Welwyn Hatfield Borough Council  
Planning Department  
Council Offices  
The Campus  
Welwyn Garden City  
AL8 6AE

**Ref: 6/2022/2801/MAJ**

Thank you for consulting us on the submitted planning application for Campus East Car Park, College Way, Welwyn Garden City, AL8 6DG. Demolition of all existing buildings and structures followed by the erection of five buildings to provide 313 residential units (Use Class C3); car and cycle parking, cycle and refuse storage, hard and soft landscaping, external lighting, drainage, infrastructure and all associated works.

Drawing Number
8375/P152.1
 Revision
A

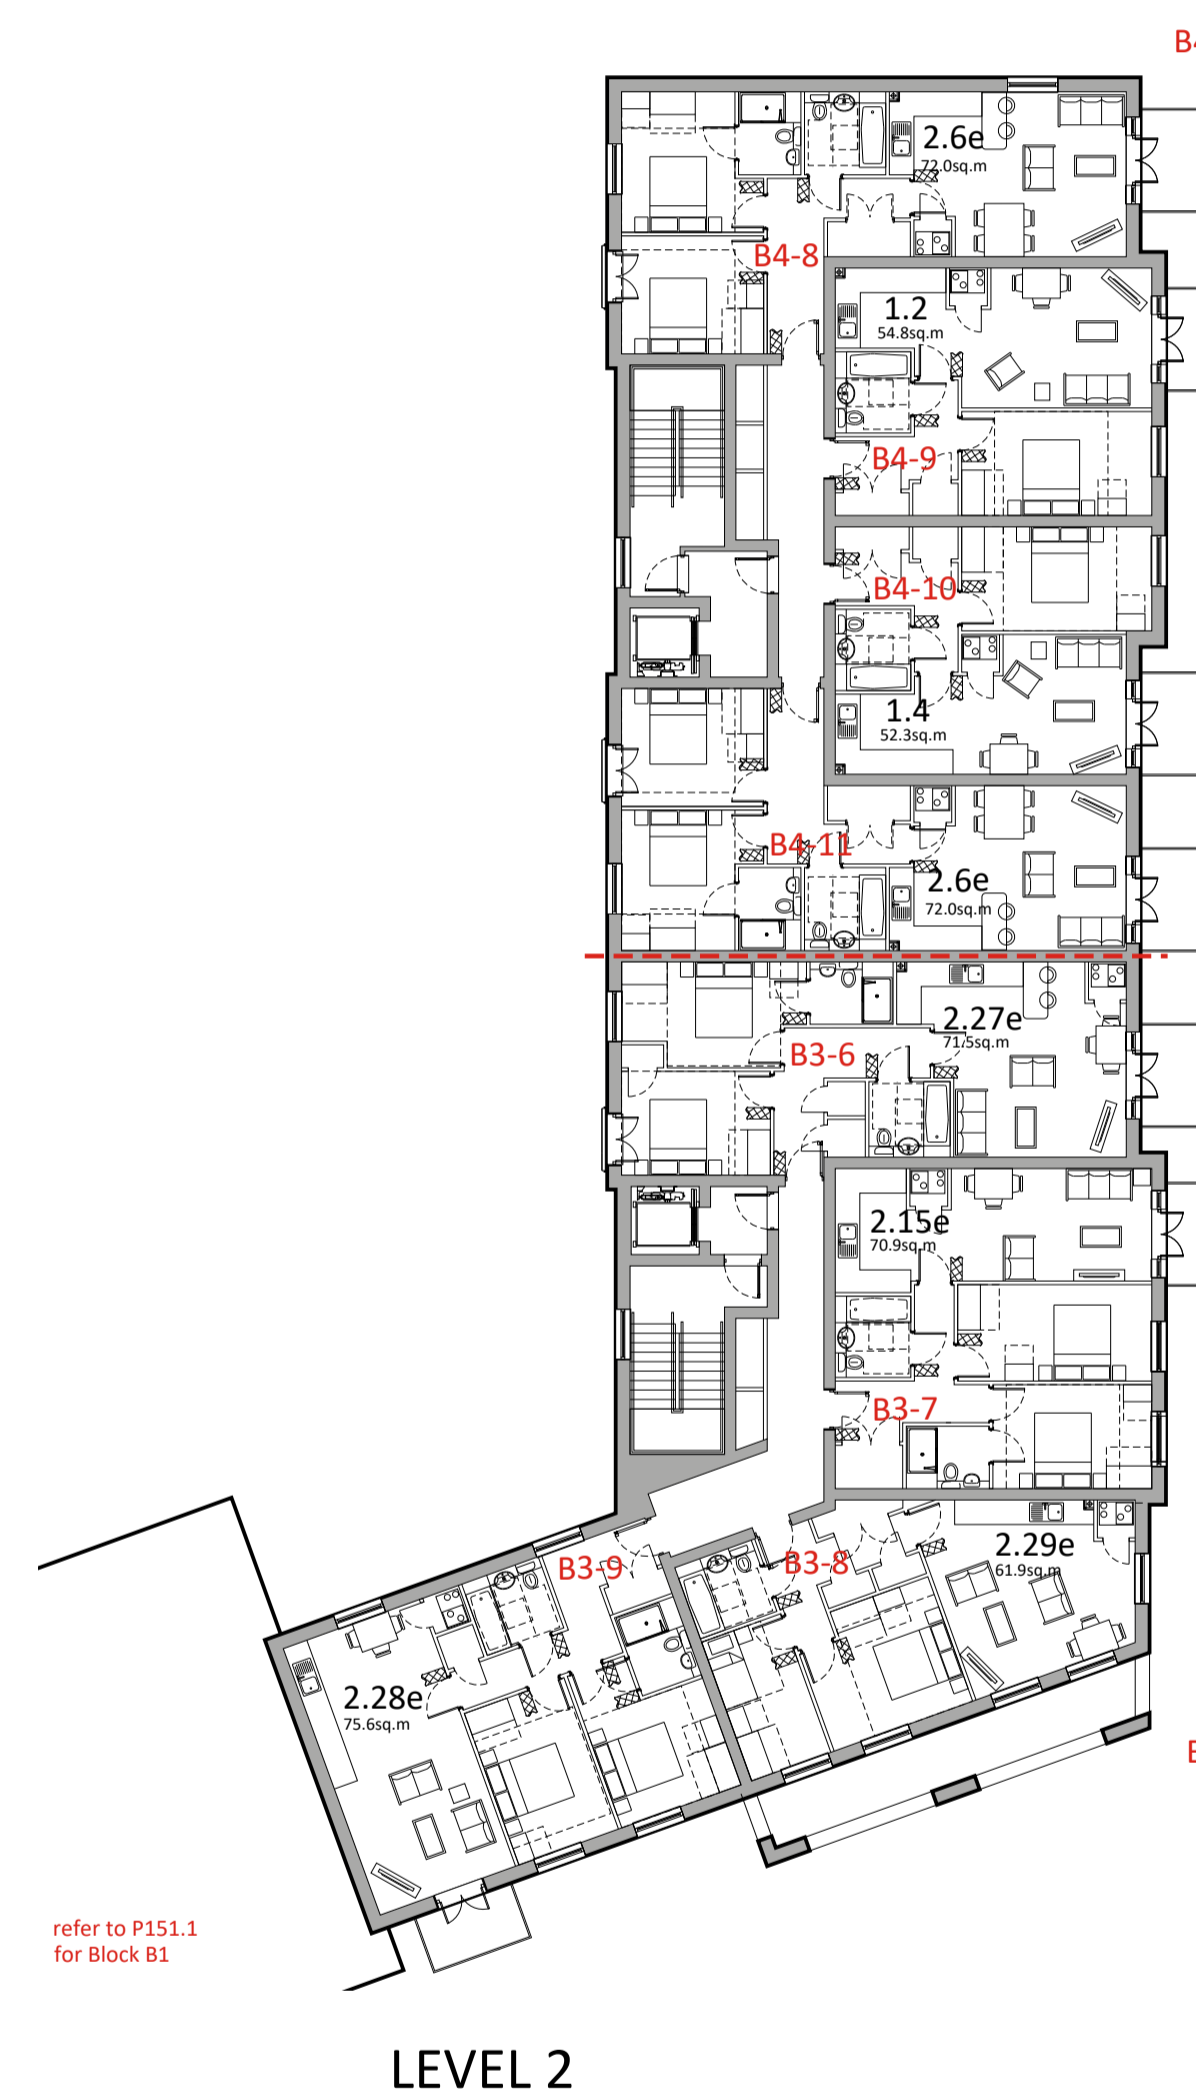
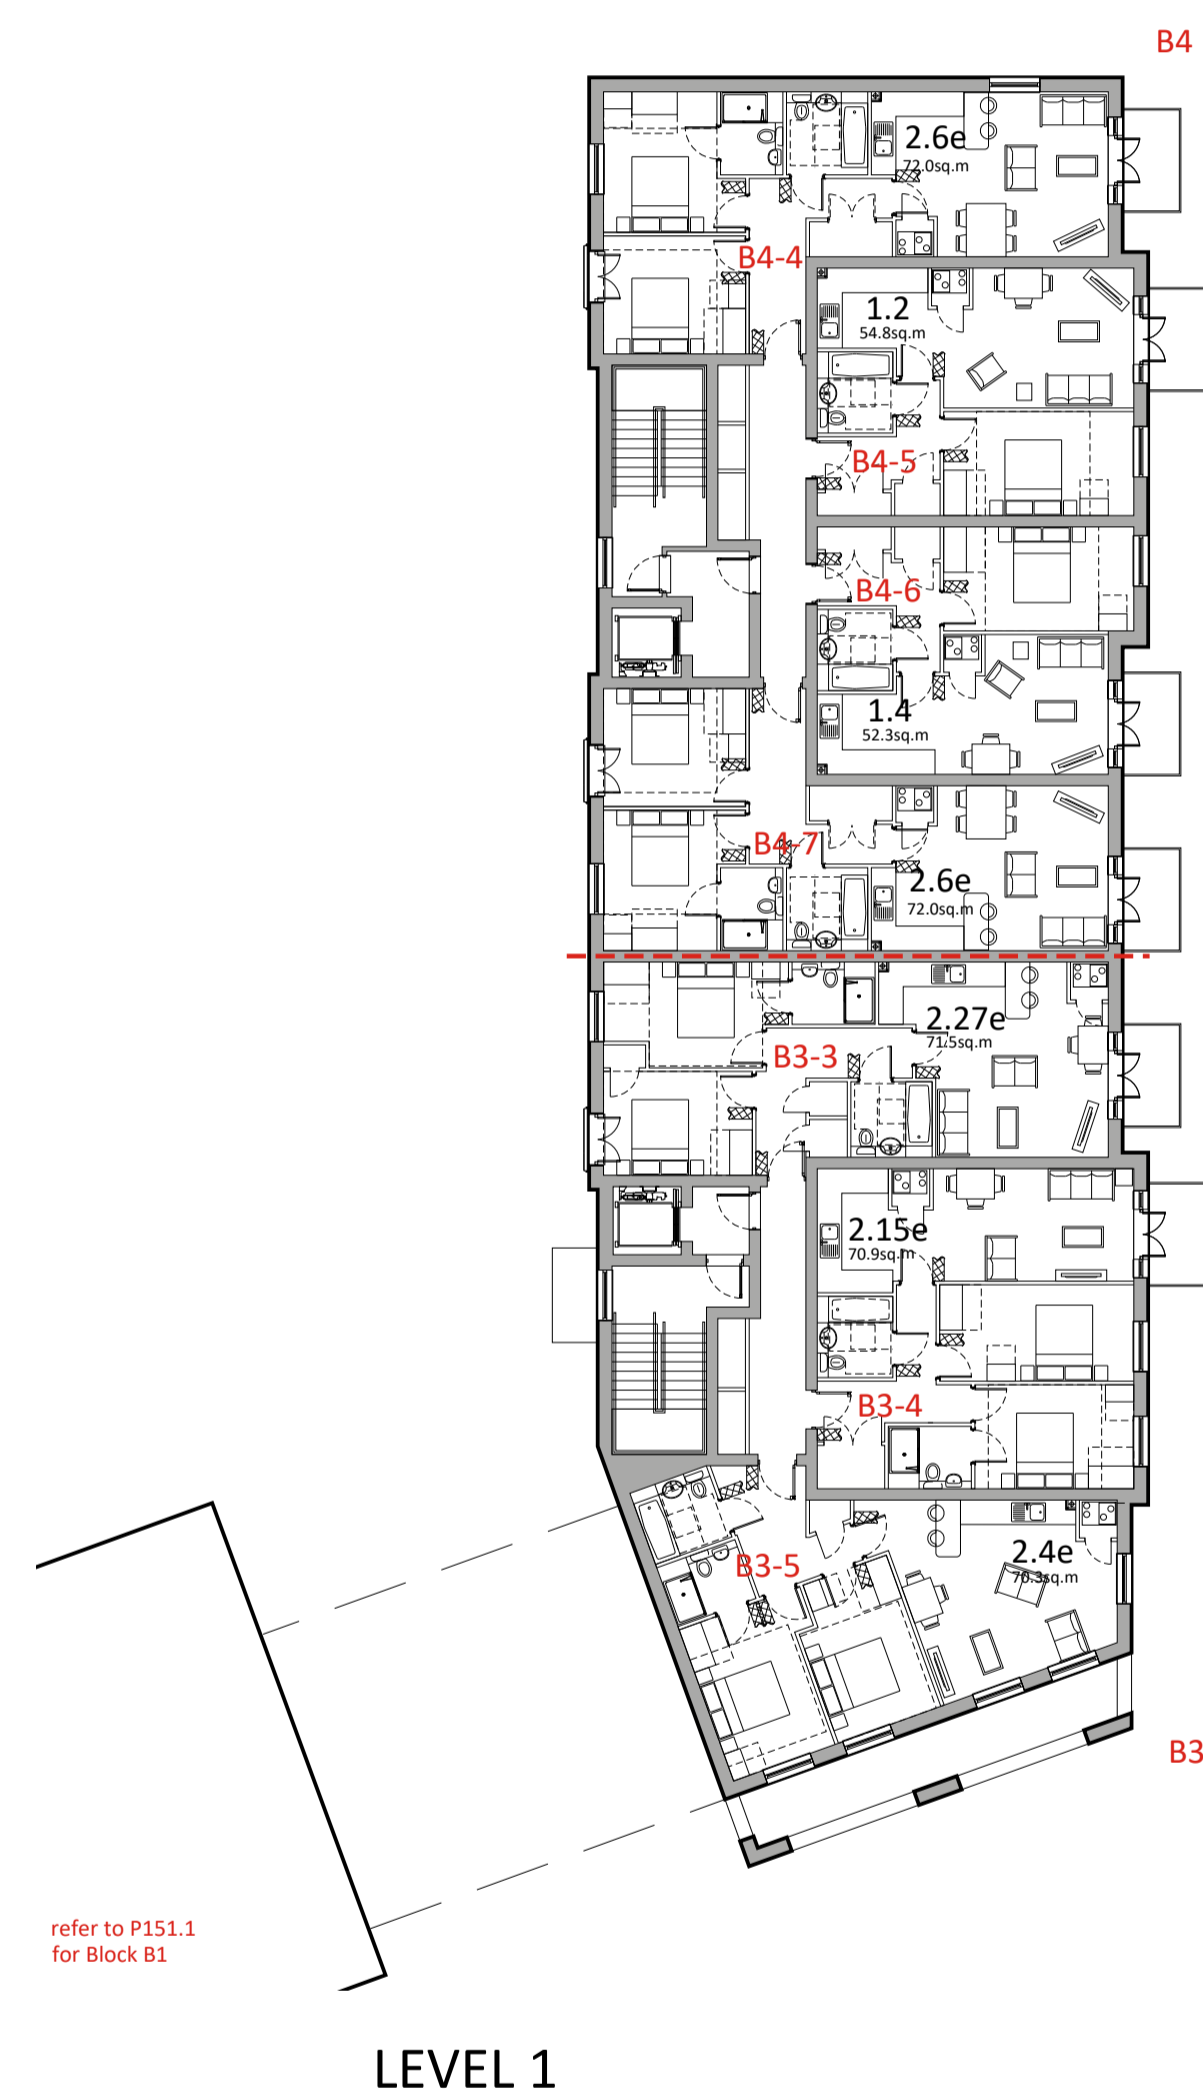
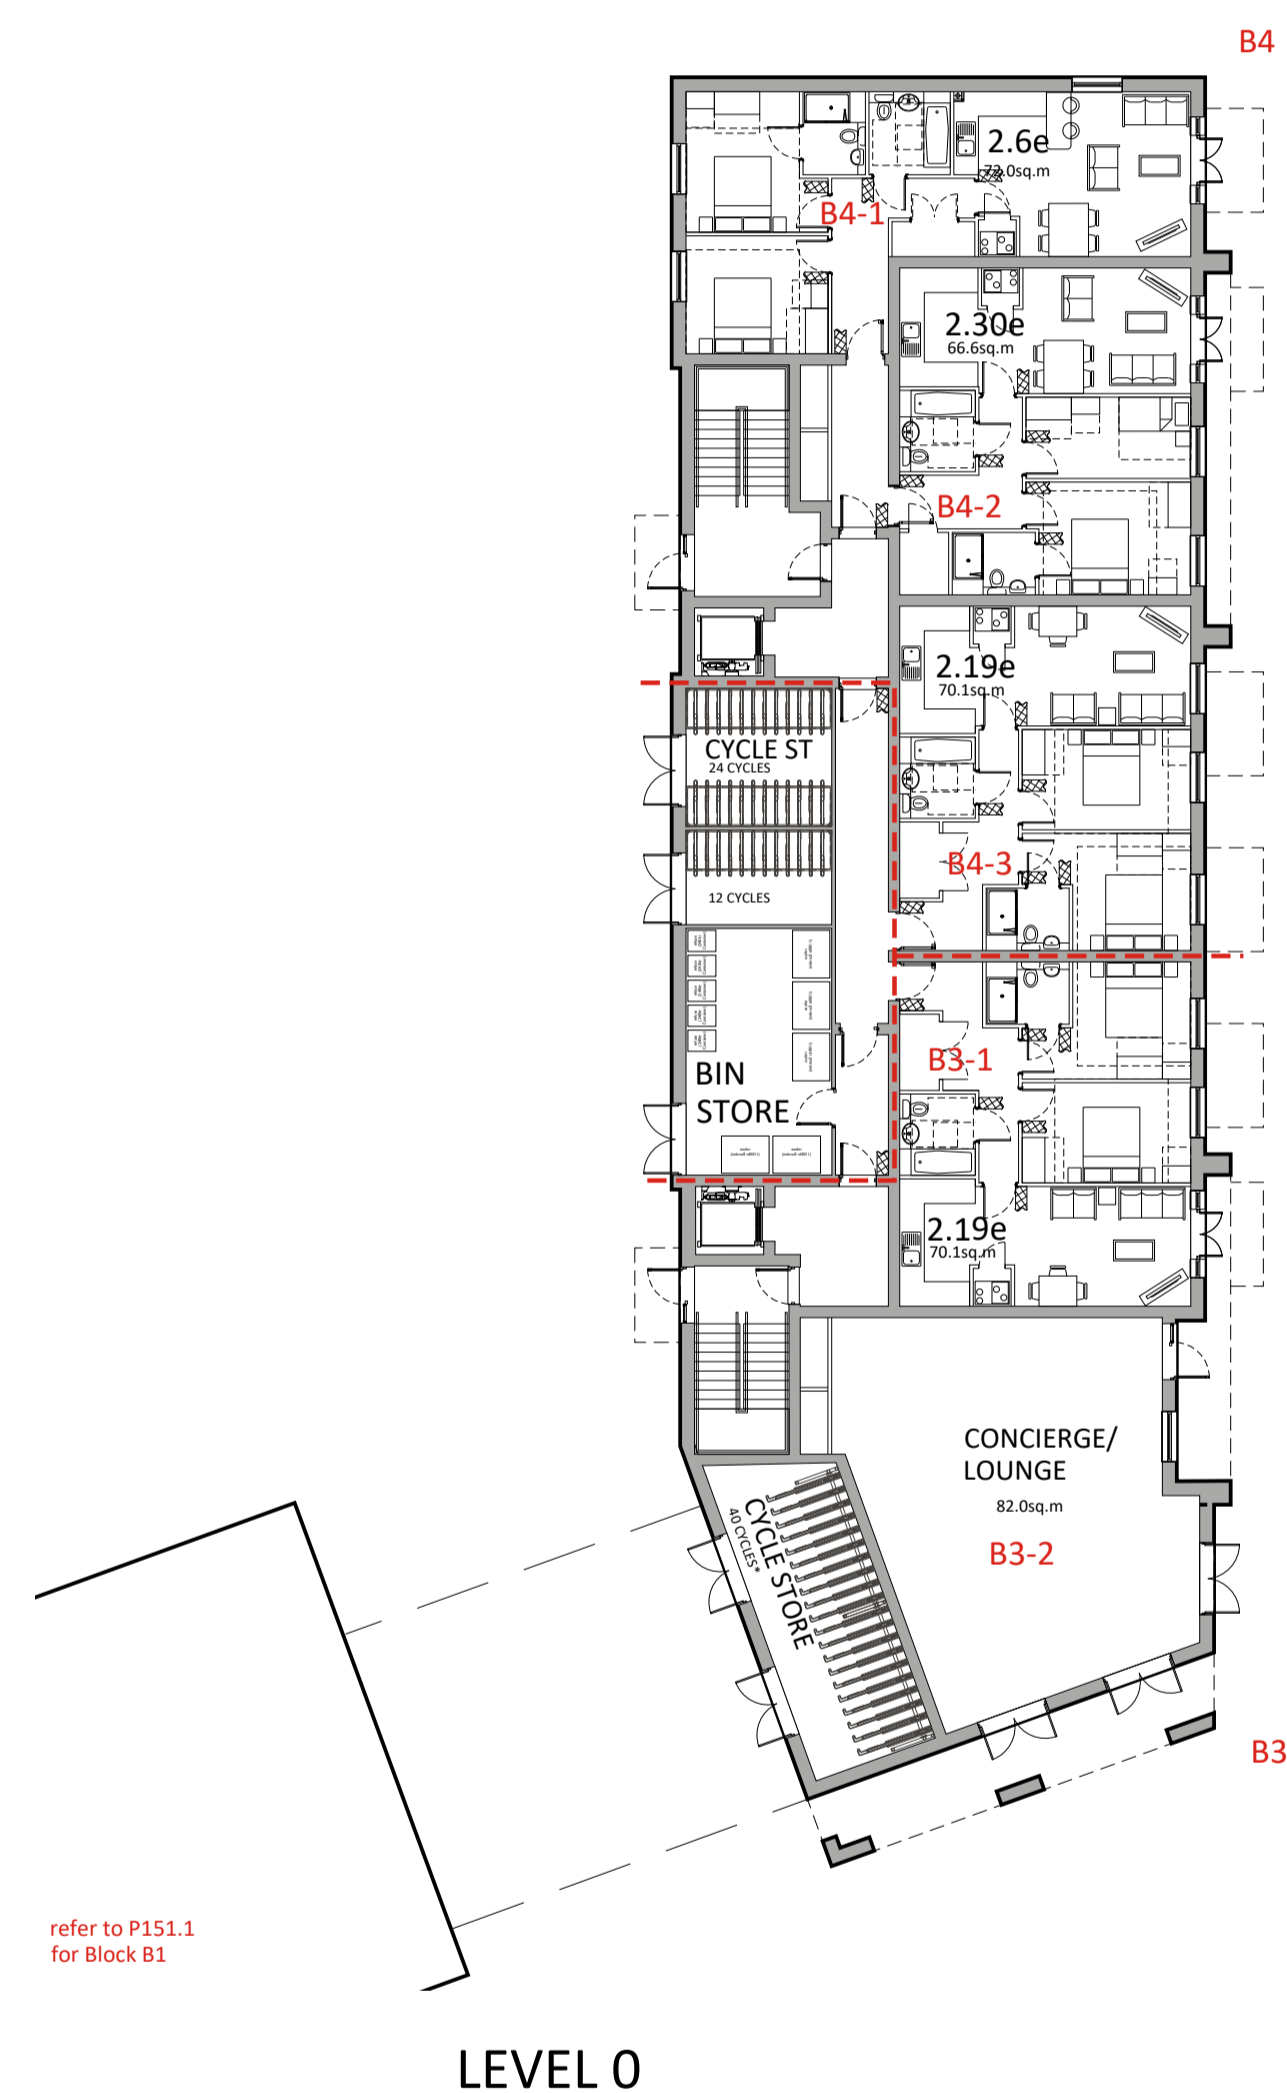
The location of the parking is logical; tucked behind the residential blocks, where walking and cycling can be prioritised. The design of the parking areas needs further thought; especially in addressing the long areas of parking without landscape or trees to help break these spaces up. The location of the delivery parking bay to the front of block B3 seems poorly located, dominating the space.
